Planning Application Ref: A/9/21/TC

Location: Pear Tree Cottage, Arundel Road, Angmering, BN16 4JR

Description of works: To reduce height of 2no. poplar from approximately 25m to 15m

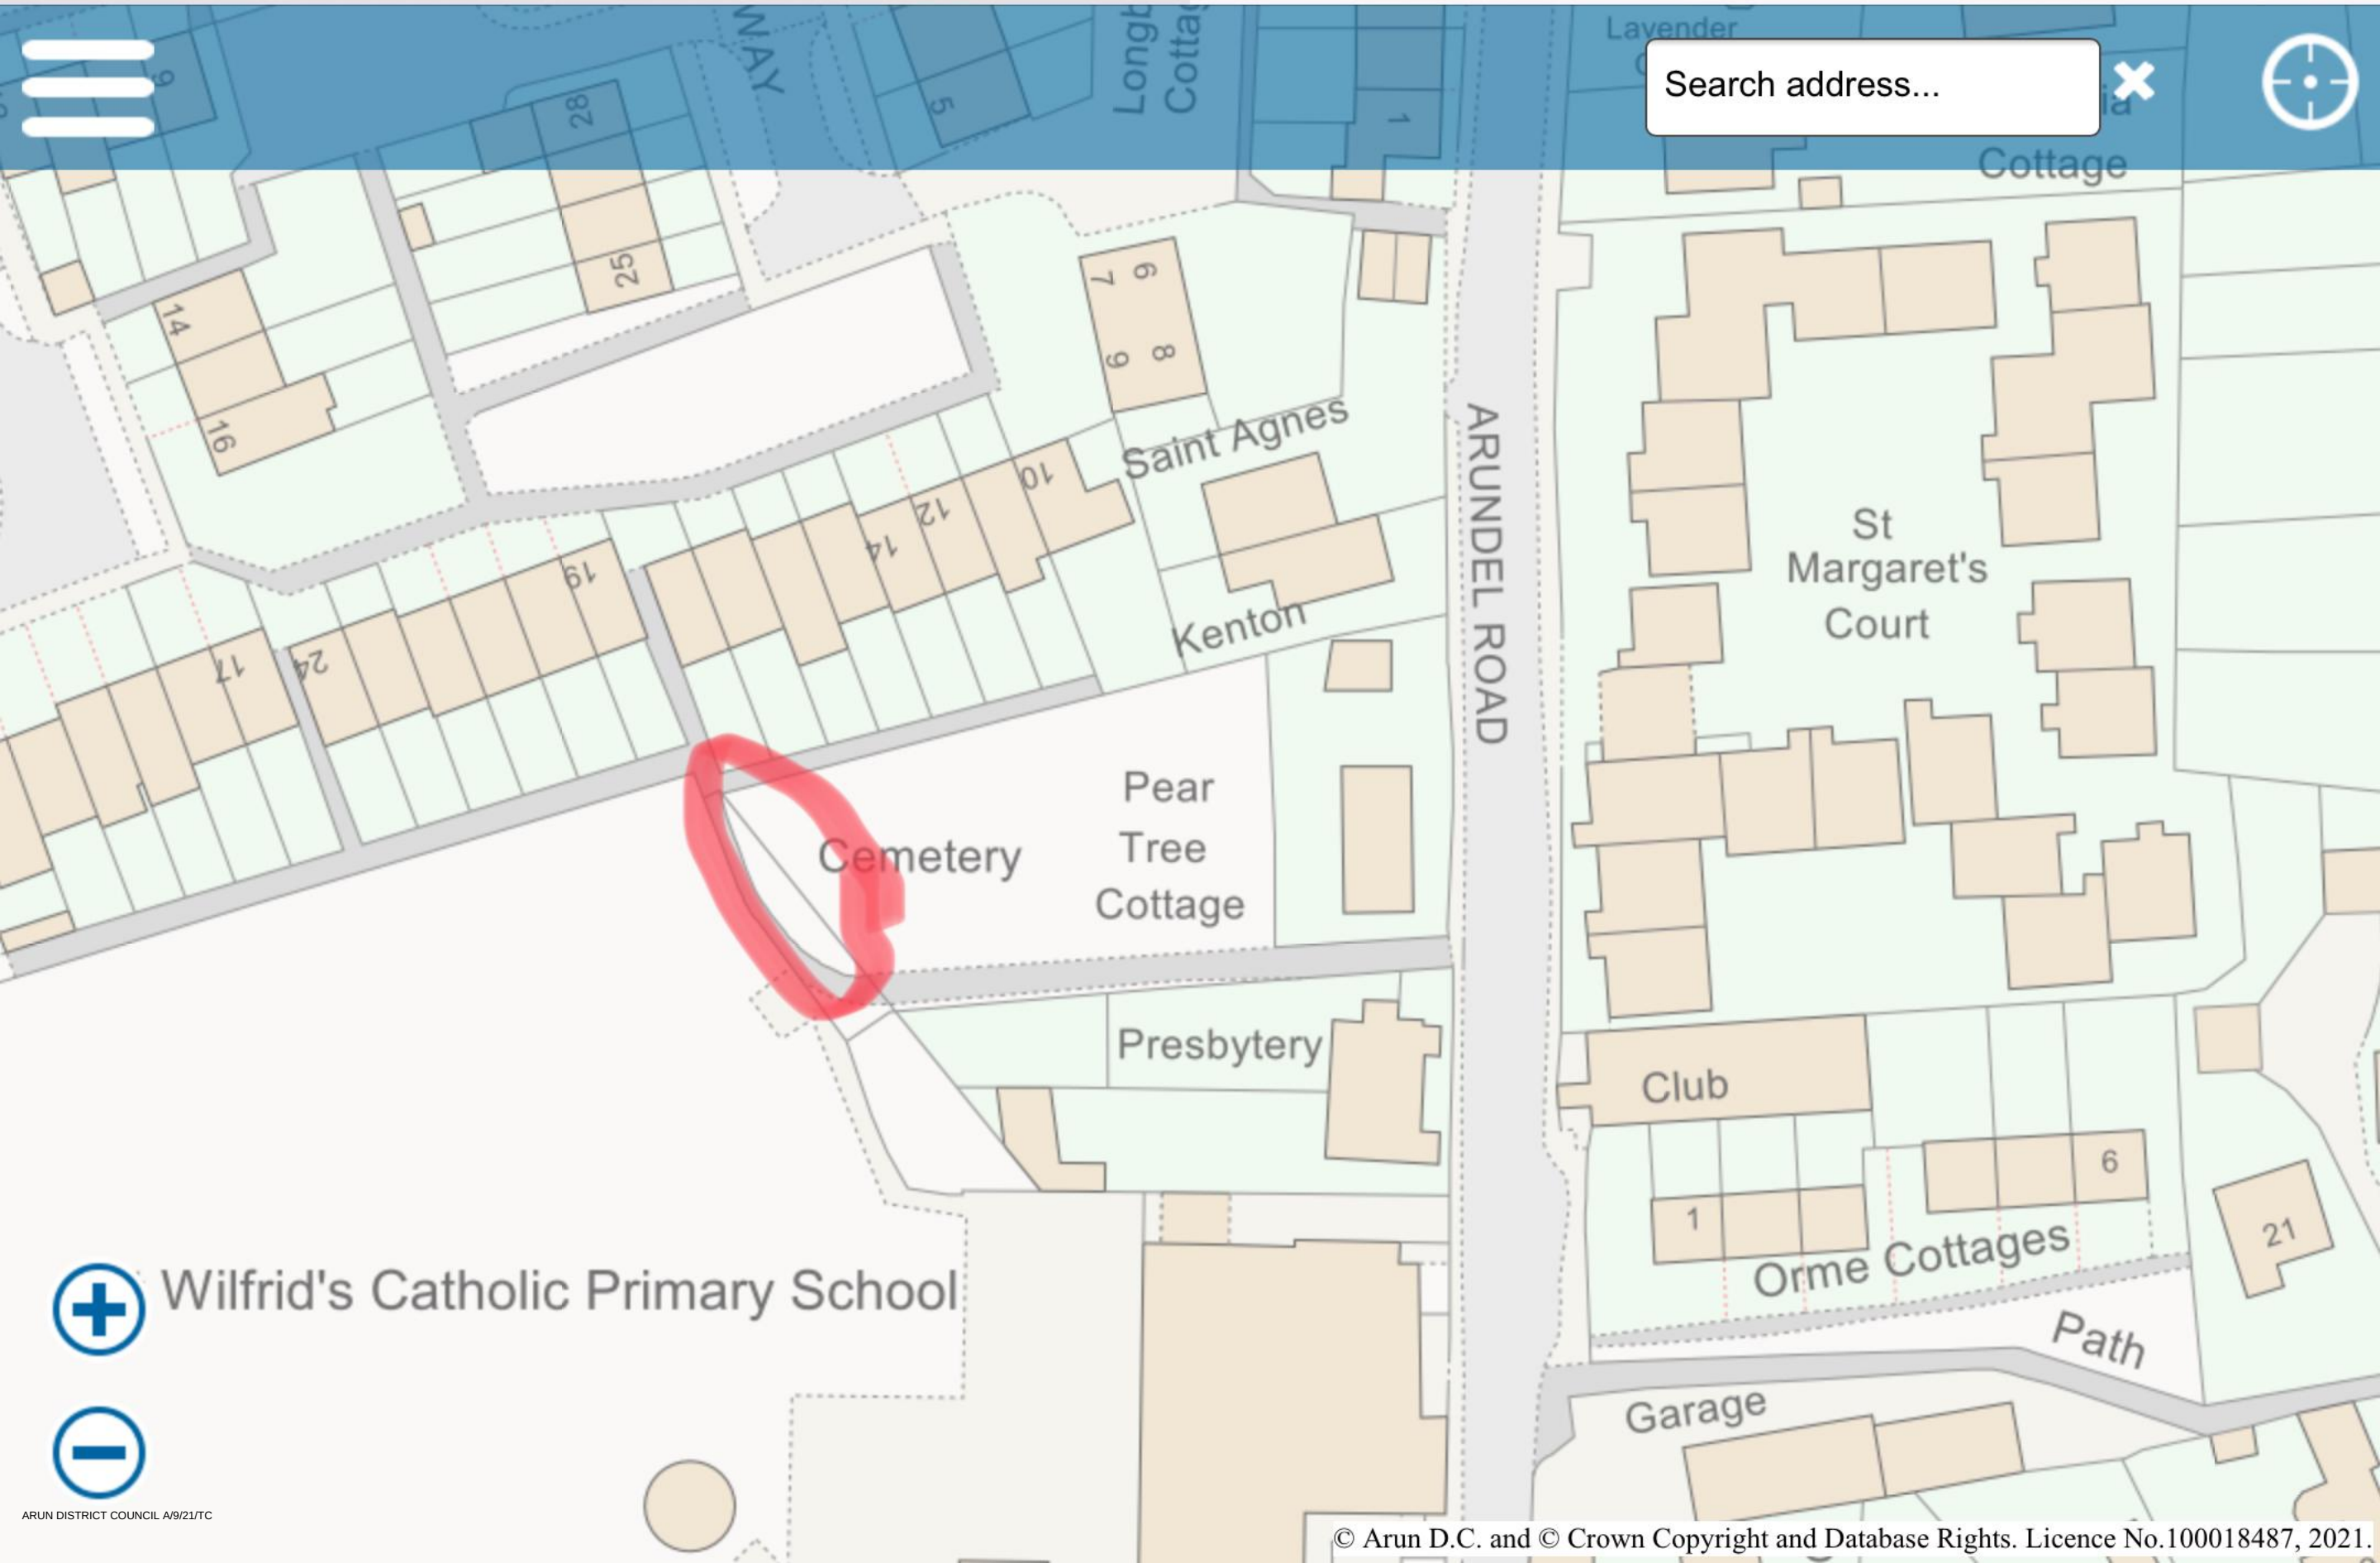
2x Lombardy poplar / *Populus nigra Italica* Approx. height: 25m Radial spread: 2.5m Age class: Early mature

- Outwardly these trees appear to be in a fine physiological state with excellent form. They have unmodified crowns so present attractive profiles and are visually impressive.
- They are visible from numerous residential properties and publicly accessible land. As such, they have amenity and landscape value.

- There is no stated or obvious justification for height reduction pruning to any extent.
- In the absence of proven significant disease or defect; the proposal to reduce height by 10m is excessive and does not comply with 'British Standard (BS3998:2010) Tree work – Recommendations' and would be likely to result in harm to the health and vitality of the trees with large pruning wounds being formed as well as undermining their visual amenity value and impact in the landscape.

- I register an **OBJECTION** to the work proposal.
- I recommend the making of a **Tree Preservation Order** to preserve both trees' place in the landscape and better control their future management. TEMPO forms and a GIS plan for this purpose can be found at the following location:
[N:_EveryoneFolders\Mark Warwick\Angmering.Arundel Road.St Wilfrids Cemetery](N:_EveryoneFolders\Mark Warwick\Angmering.Arundel Road.St Wilfrids Cemetery)
